Addendum No. 3

RE: Contract ID C203409

Jackson County (B-4554)

Bridge #145 Over SR-1705, Southern Railroad and Scott Creek

PHASE II DETAILS

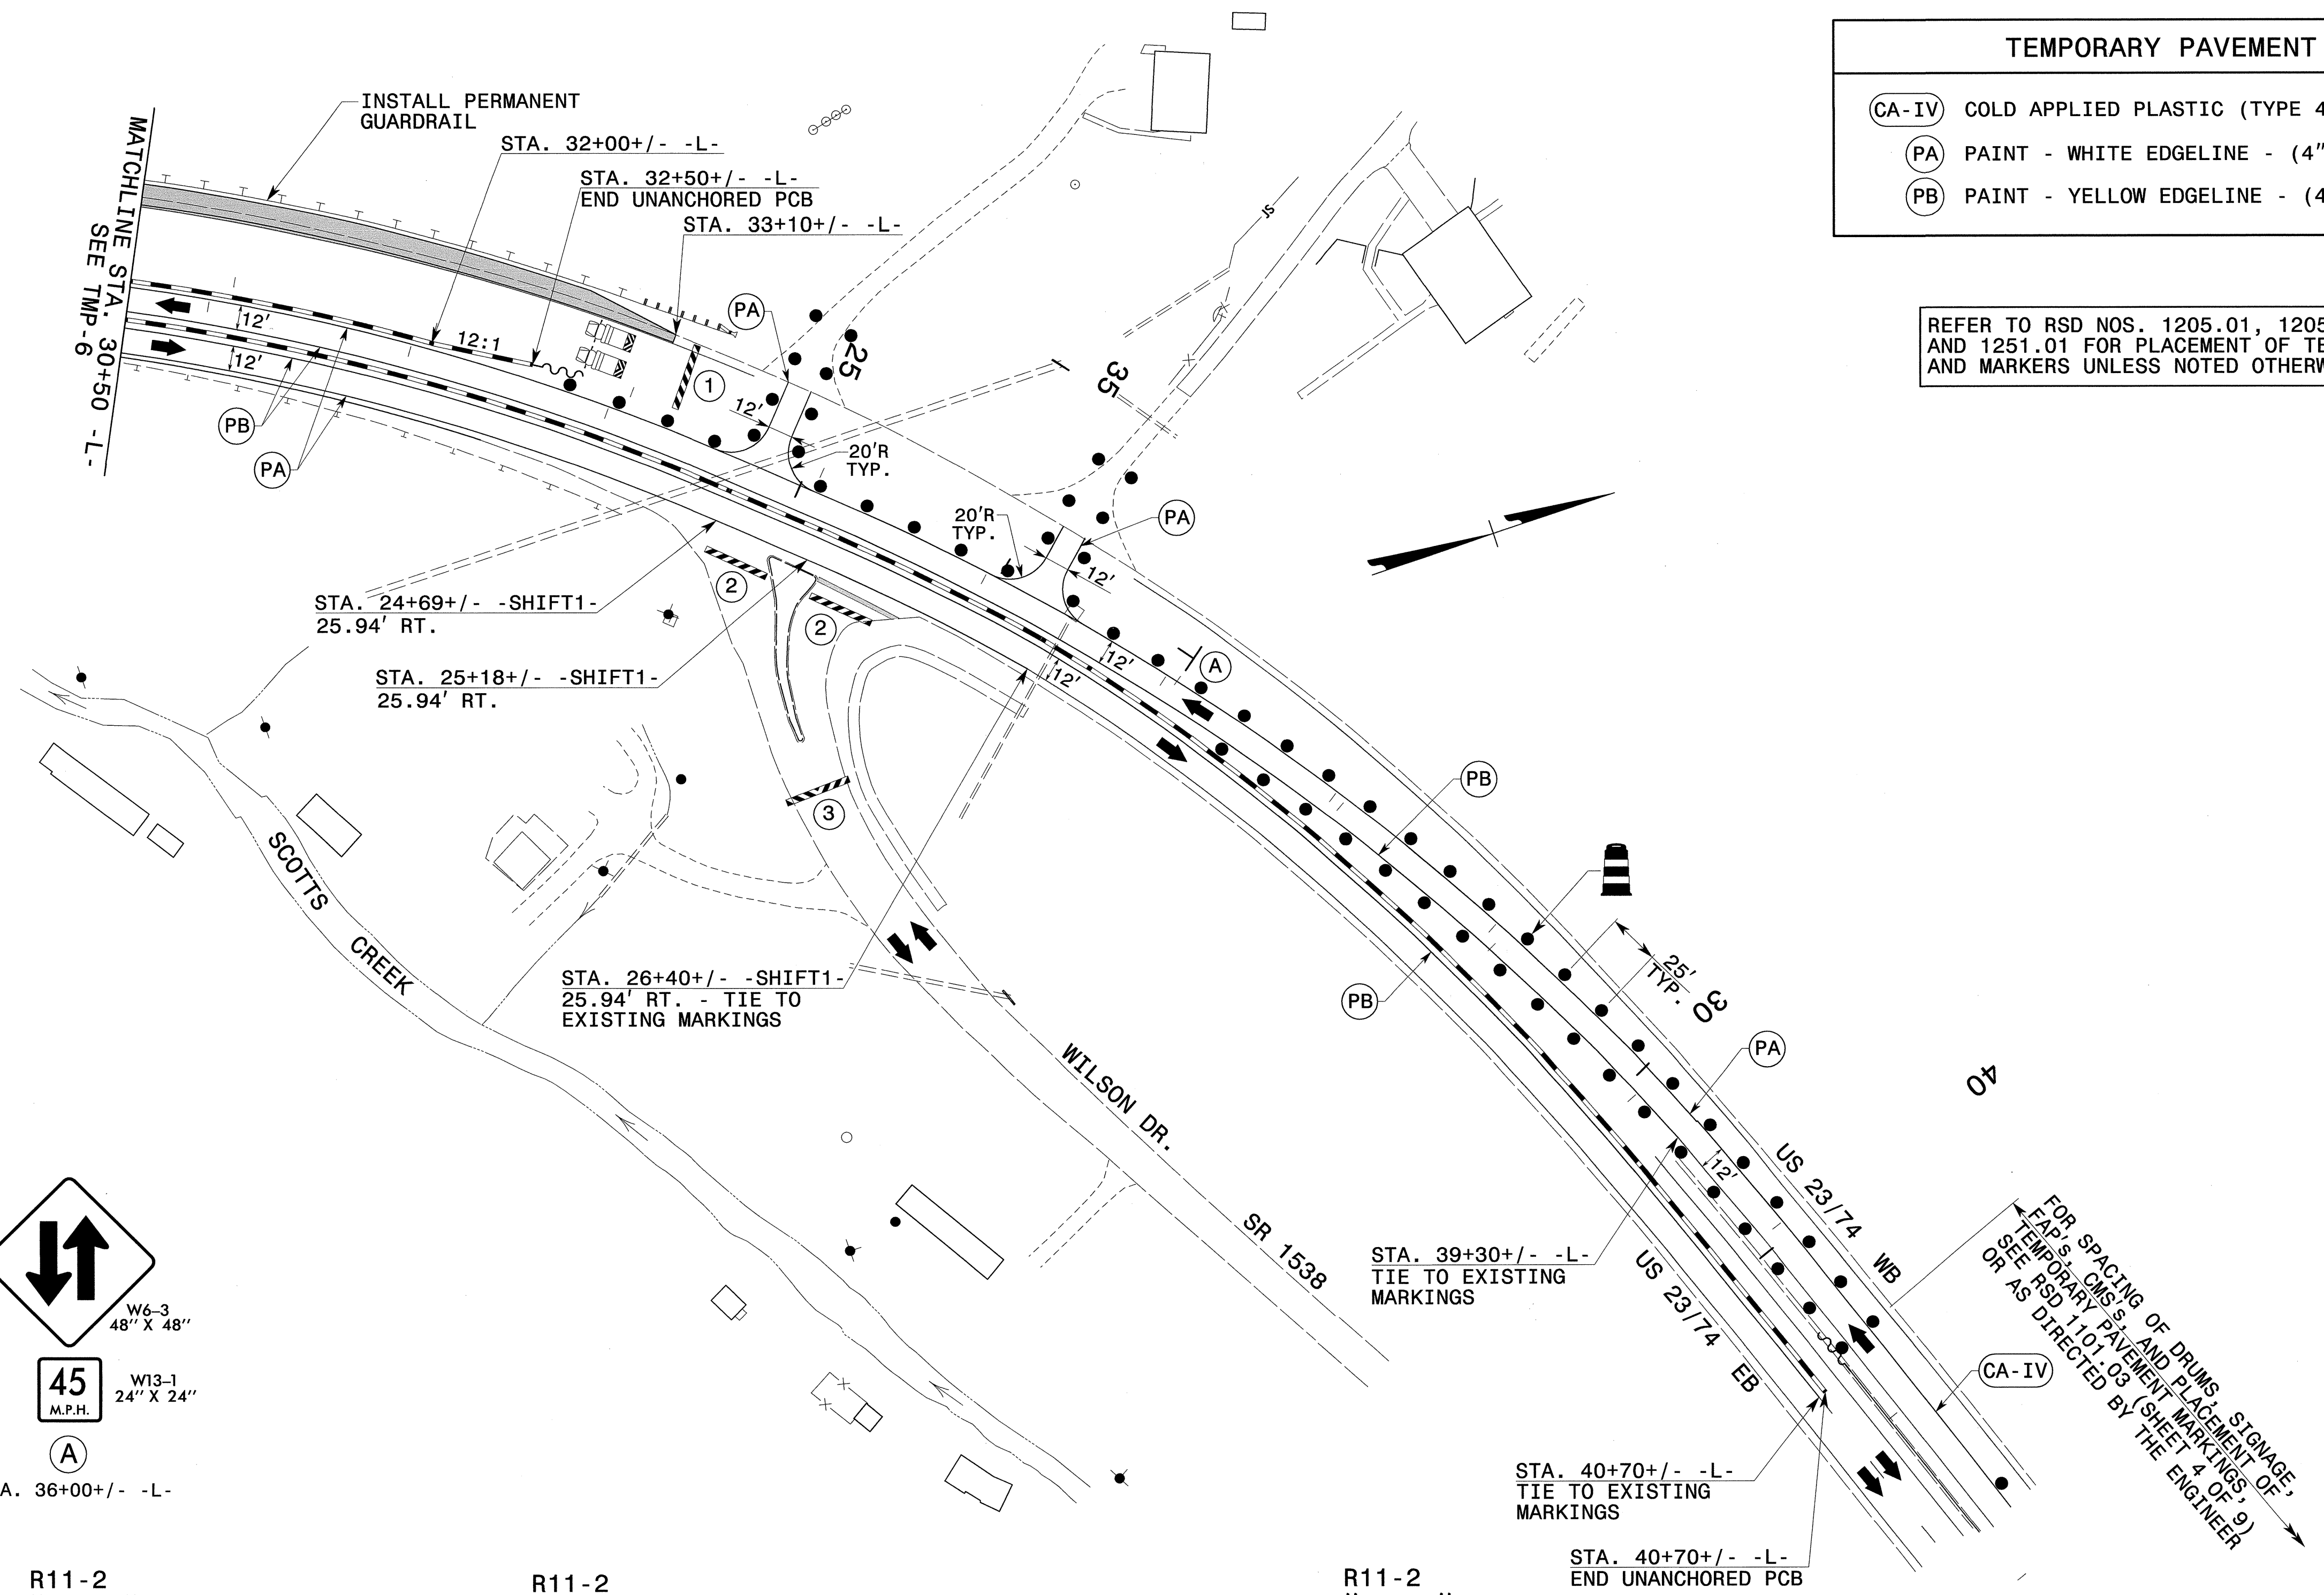
Sheet No.	Revisions
TMP-3	Revised the work to be performed in Phase II and Phase III
TMP-6	Show drums on right side of -Y1- in lieu of installing permanent guardrail in this temporary pattern
TMP-9	Require installing permanent guardrail on -Y1-
